M25 junction 10/A3 Wisley interchange TR010030 9.5 DCO Application Errata Schedule

9.5 DCO APPLICATION ERRATA SCHEDULE

Regulation Number:	Regulation 5(2)(q)
Planning Inspectorate Scheme Reference	TR010030
Additional Submission Reference	TR010030/AS-021 (2)
Author:	M25 junction 10/A3 Wisley interchange project team, Highways England and Atkins

SHEET **4** OF 31

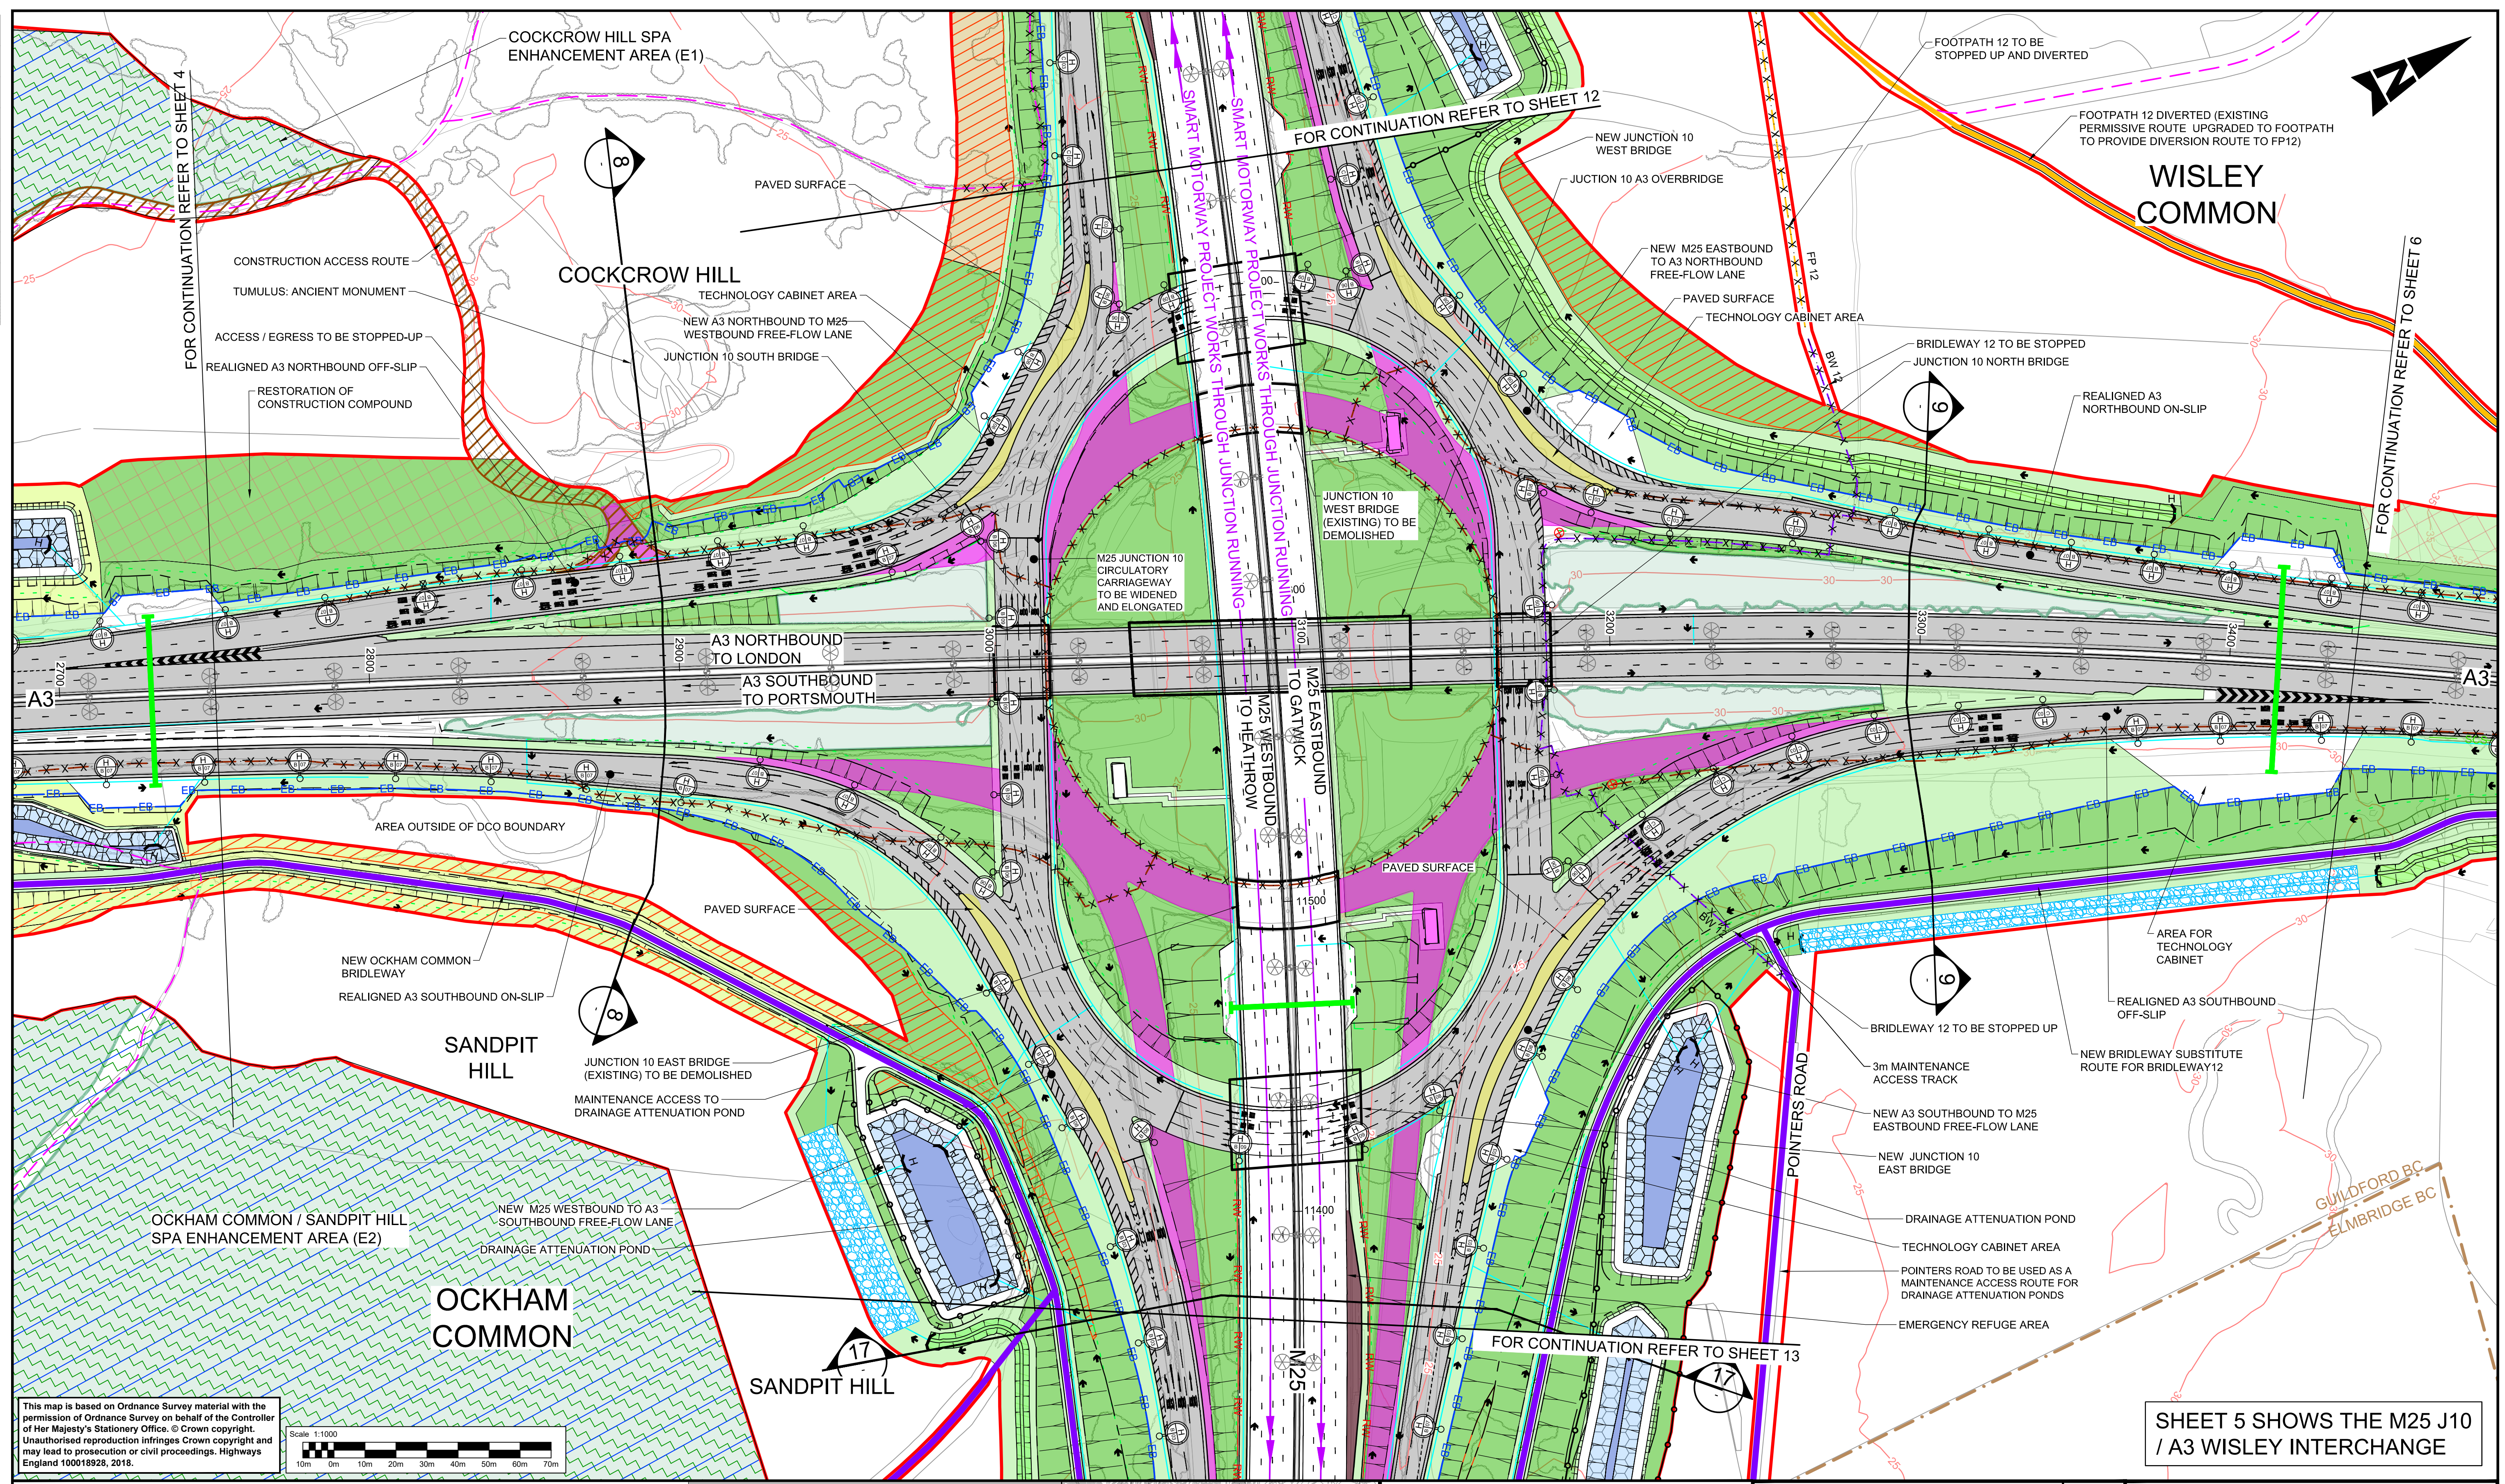
APP-012	2.8 Scheme Layout Plans	Sheet 4 of 31	The label reading "Existing access to Ockham Common car	Remove label

PINS Application Document Reference	Document name:	Section	Nature of Erratum and explanation	Correction
	(Sheets 1-10 of 31)		park/Ockham Bites café to be stopped up and reprovided” is incorrect and to be removed.	
APP-012	2.8 Scheme Layout Plans (Sheets 1-10 of 31)	Sheet 6 of 31	The hatched area marking the restoration of temporary possession land north east of the Gothic Tower incorrectly extends beyond the DCO boundary and to be removed.	Remove the hatched area which falls outside the DCO boundary.
APP-012	2.8 Scheme Layout Plans (Sheets 1-10 of 31)	Sheet 7 of 31	The label reading “New B365 Seven Hills Road extension” is incorrect and should be changed.	New private means of access and bridleway.
APP-012	2.8 Scheme Layout Plans (Sheets 1-10 of 31)	Sheet 7 of 31	The label reading “New Red Hill substitute access” is to be removed.	Remove label.
APP-012	2.8 Scheme Layout Plans (Sheets 11-31 of 31)	Sheet 11 of 31	The area of the scheme plan commensurate with Plot 11/11 incorrectly shown as SPA compensation land.	Change the scheme plan to remove this area from SPA compensation land.
